**Re: The Boulders Phase 1 Subdivision Drainage Report and Grading and
Drainage Plan**

Engineer's Stamp date 4-29-11 (B11/D001B)

Based upon the information provided in your submittal received 4-29-11, the above referenced report and plan cannot be approved for Preliminary Plat action by the DRB until the following comments are addressed.

DIVERSION BERM (EARTHEN) DETAIL
SC: NTS

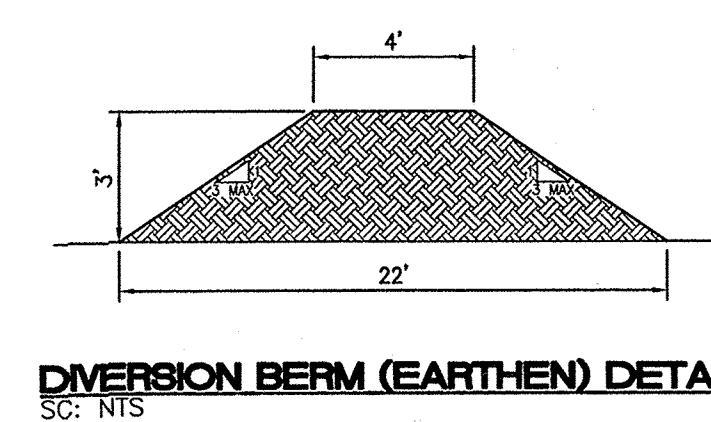
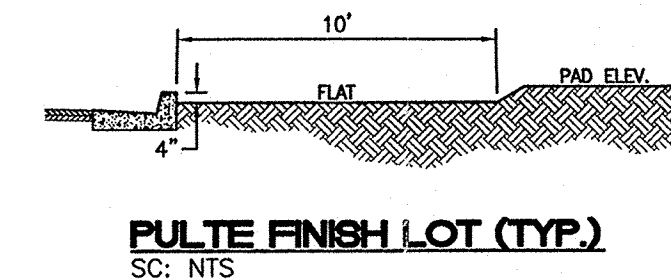
- Provide a detail of the Temporary Diversion Berm. The proposed grades in this area are not representative of a berm.
- The flood wall is to be built per Work Order, so details are not required on the Grading Plan.

SHEET #
1

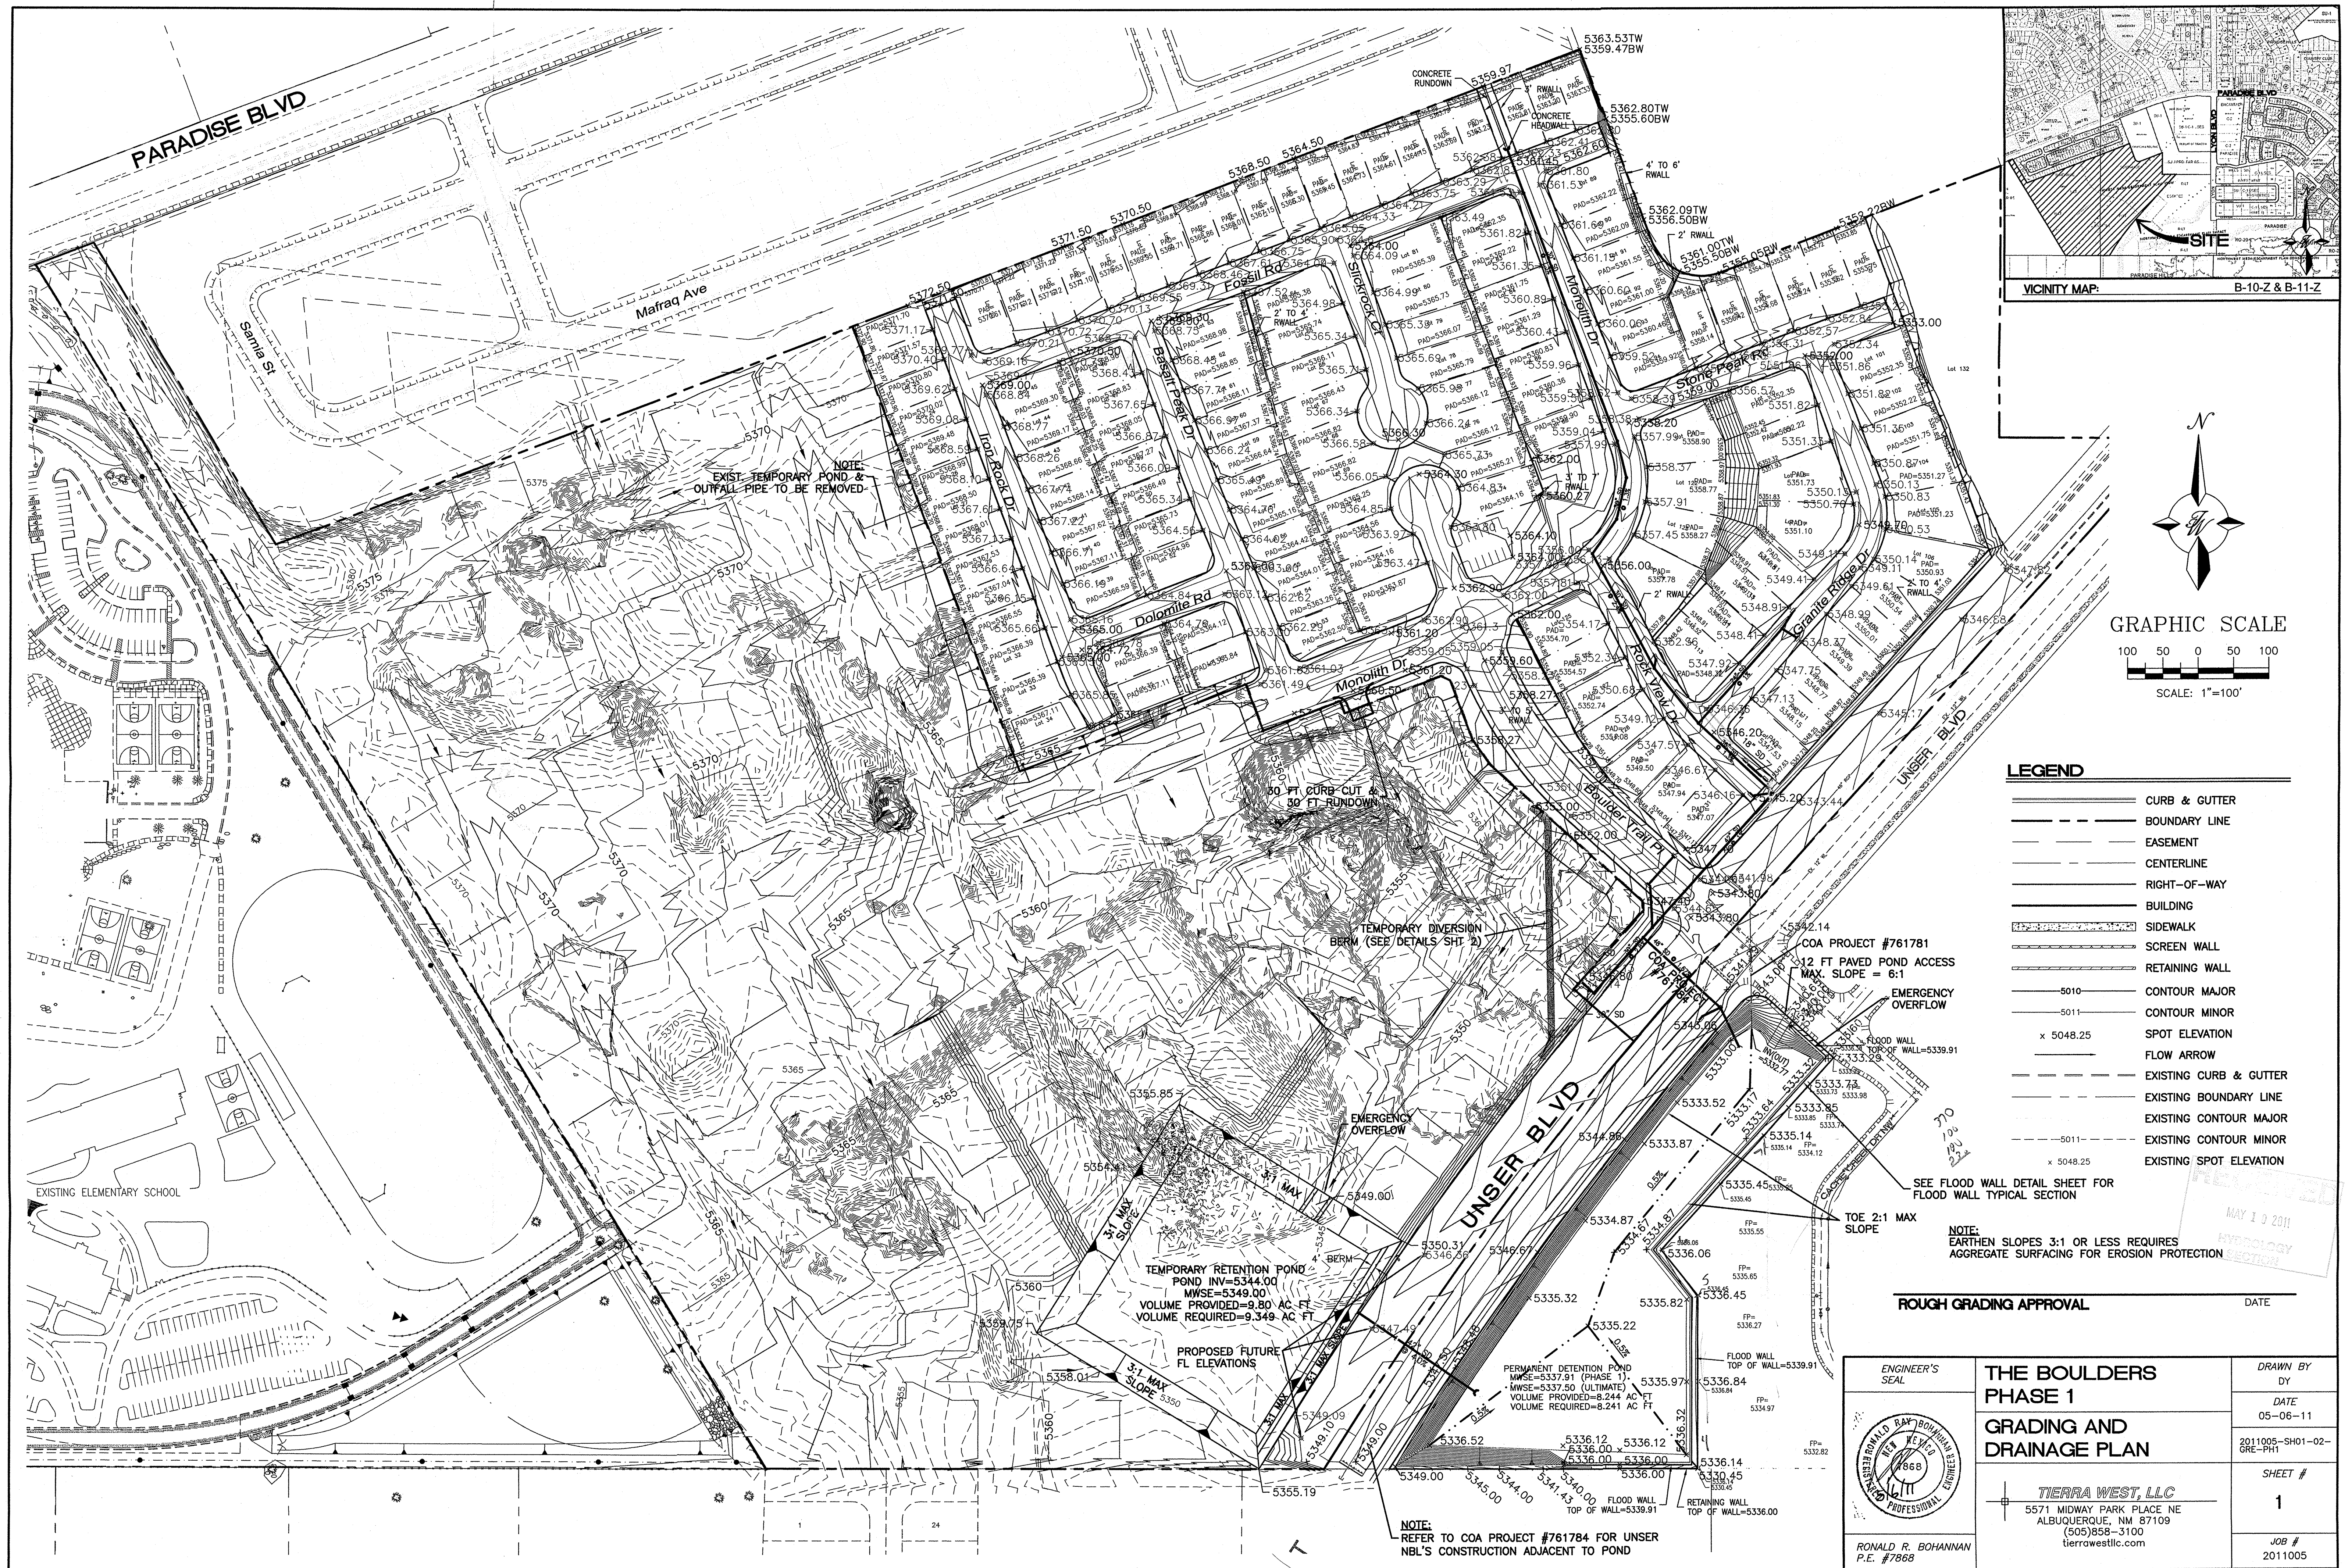
- It is not clear how runoff is getting to AP3. Show the curb cut or similar.
- Show what is to be built to accept runoff from upland east in Tract C.
- Detention pond bottoms are to be sloped a minimum of 0.5 %. This will affect the proposed required volume. The low-flow channel can be shown on the Work Order.

- It appears the side slopes in the Unser Pond are too steep to support a maintenance road. The max slope is 10:1 gravel or 6:1 hard surface. This may affect the pond volume.

- Side slopes for the Unser Pond appear to be 2:1 along Unser and 1:1 along the west side. Provide slopes on the Grading Plan. Aggregate or riprap may be used for erosion control on slopes steeper than 3:1.

- Provide the proposed flow line in Unser Blvd along the Temporary Retention pond. What slope are the tie slopes to Unser Blvd?
- Label proposed contours every 5 feet.

- It appears a retaining wall is required between the northern lots between Slickrock Ct and Basalt Peak Dr.
- Label retaining walls per legend. TW/BW or FGH/FGL are required. Put on a different sheet if necessary.

- At AP 9 there is about 50 cfs in the street and four inlets for it to drain into. There cannot be any bypass, therefore it appears more inlets should be added to the storm drain. This can be addressed at Work Order.
